The Sizewell C Project, Ref. EN010012

**Issue Specific Hearing 5 (13 July 2021) – (ISH5)
Landscape and Visual Impact and Design**

**Post Hearing Submissions including written
summary of Suffolk County Council's Oral Case**

Deadline 5

Figure 8.26: Visualisation of the sea defence

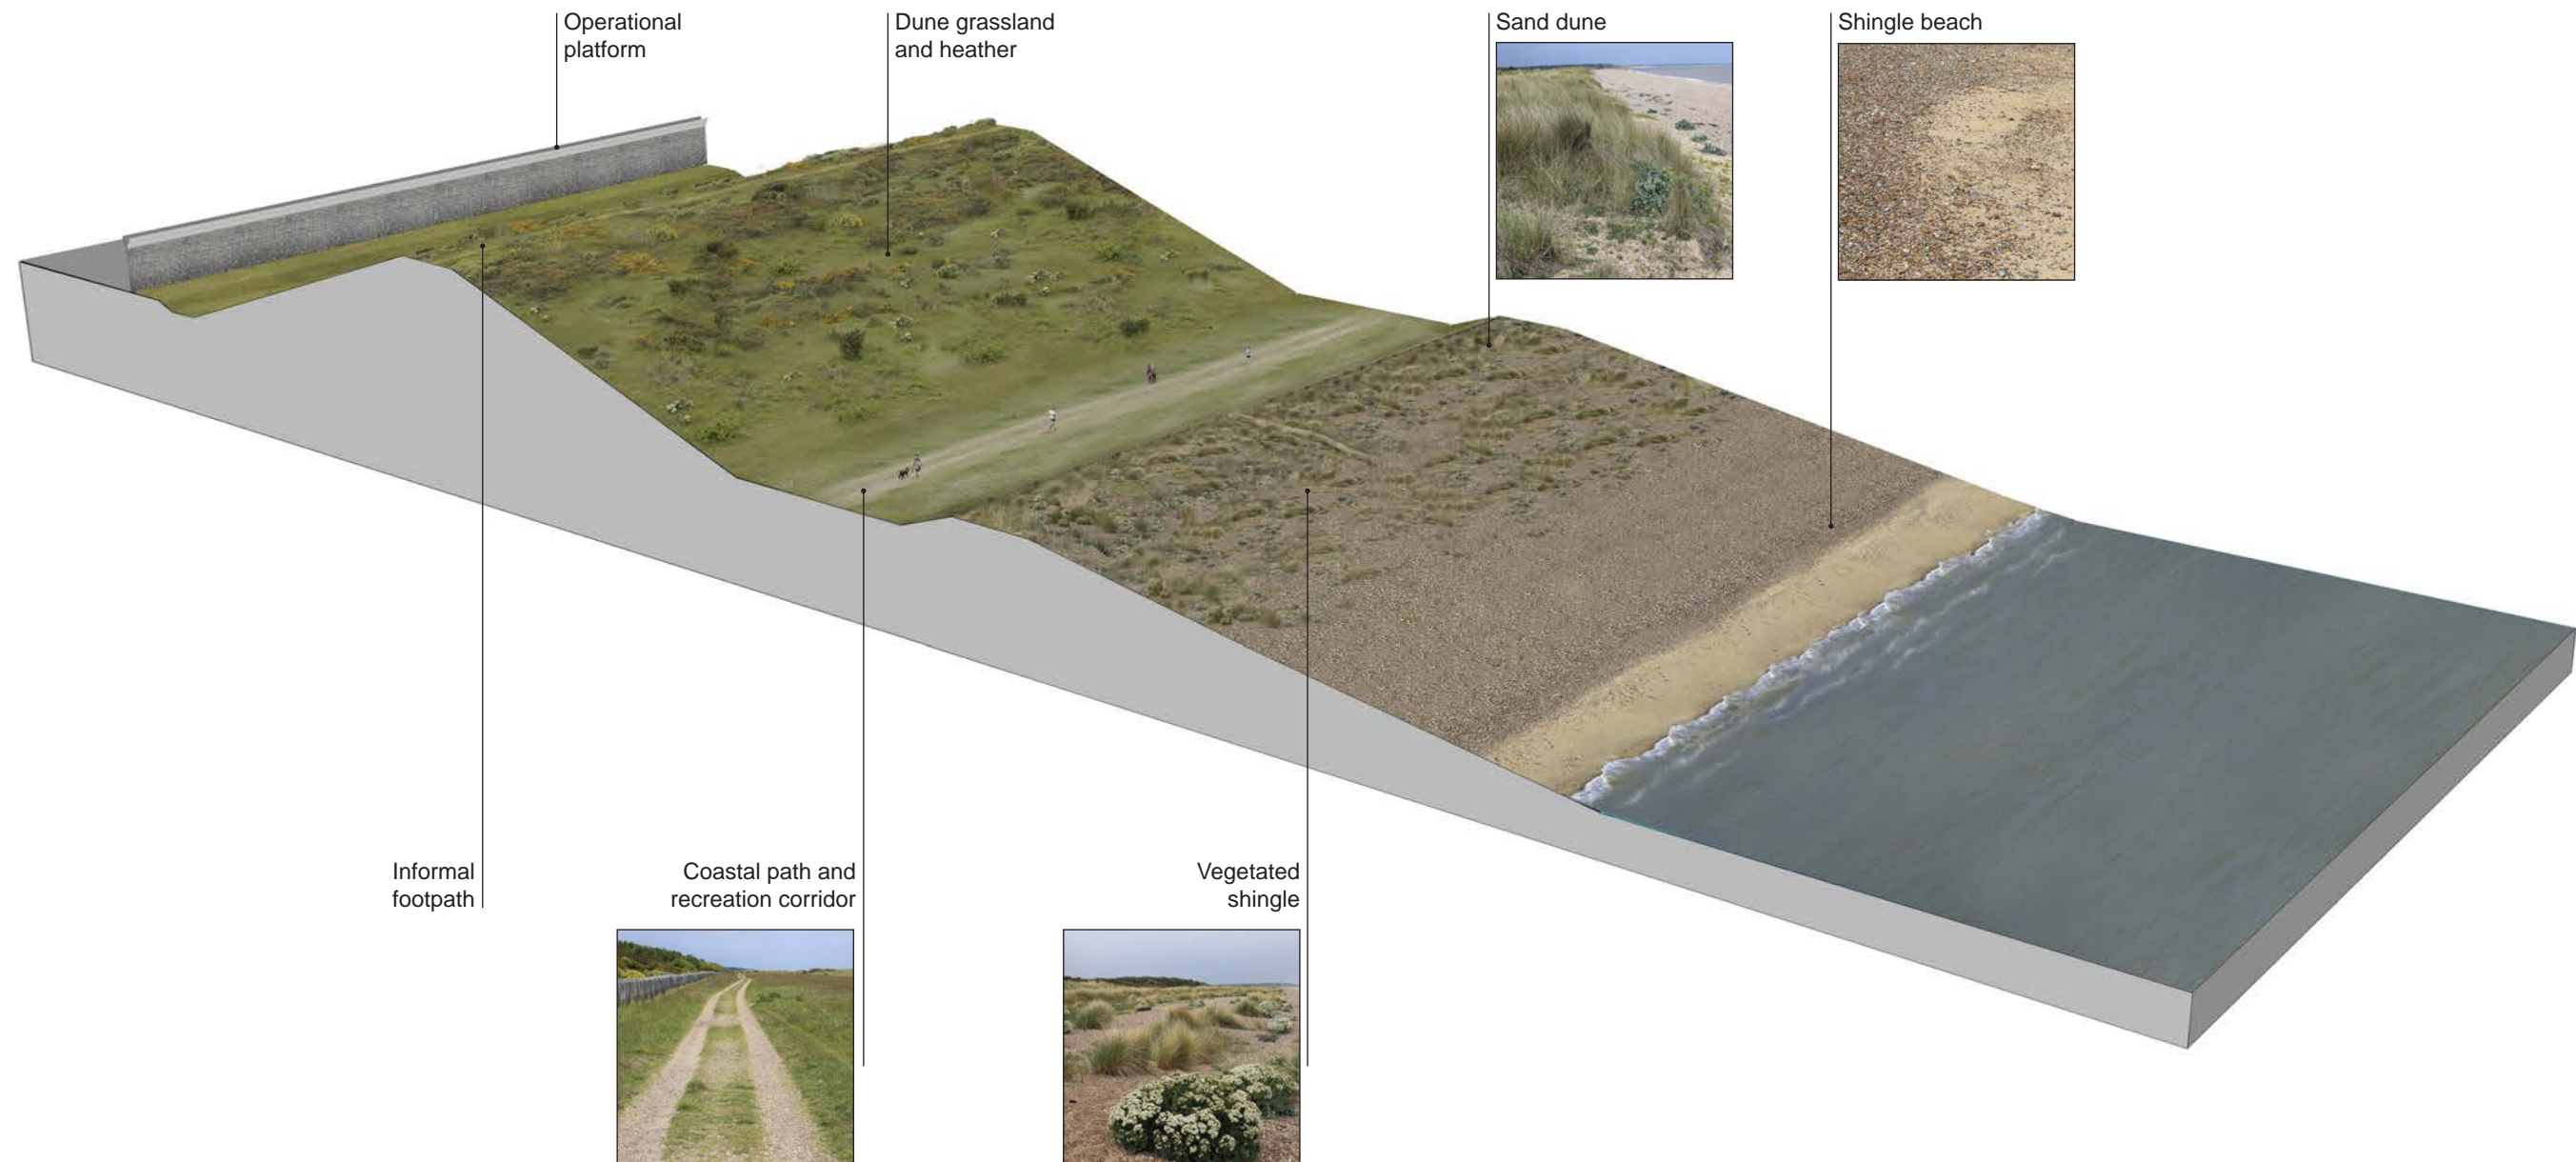
Impacts of the sea defences on the character of the coastal landscape	The design, extent and composition of the sea defences remain unresolved at present, therefore the extent and nature of the adverse impacts on the character of the coastal landscape are not yet clear. SCC notes the information regarding soft coastal defences (Rep3 004) and beach recharge (REP3-032 & REP3-048) submitted by the applicant at deadline 3. This information indicates additional risks to the character and amenity of the coastal frontage. However, SCC asks to reserve its position until publication of further information by the applicant at Deadline 5.	REP3-032 REP3-048 Rep3 004
Agenda Item 3 - Landscape and Visual Impact Assessment (LVIA)		
<i>Adequacy of LVIA – Assessment</i>	<p>SCC anticipates that the LVIA will require further revision, (like that already undertaken in respect of the revised Beach Landing facilities (AS 206)). Following the publication of details of the sea defence design, at Deadline 5 - It is anticipated that this is likely to resolve the LV5 - 6 and 8 regarding <i>adequacy of assessment</i> in the SCC/ESC Joint Statement of Common Ground REP2-076</p> <p>Whilst significance of adverse effects is currently at the highest level and is not expected to change, the impact of the revised sea defence design, in terms of character and the qualitative, experiential issues, and vegetation cover, needs be understood and evaluated particularly given the importance of this area as public realm.</p>	REP2-076 LV5 6 & 8

<i>Need for updating of the LVIA in respect of sea defences</i>	Therefore, an update of the “Visualisation of the sea defence” Figure 8.27 in part 2 of the DAS APP-586 will also be required	APP-586 p199
<i>Adequacy of LVIA - scope and methodology</i>	SCC is satisfied that the <i>scope and methodology</i> of the LVIA is acceptable.	REP2 – 76
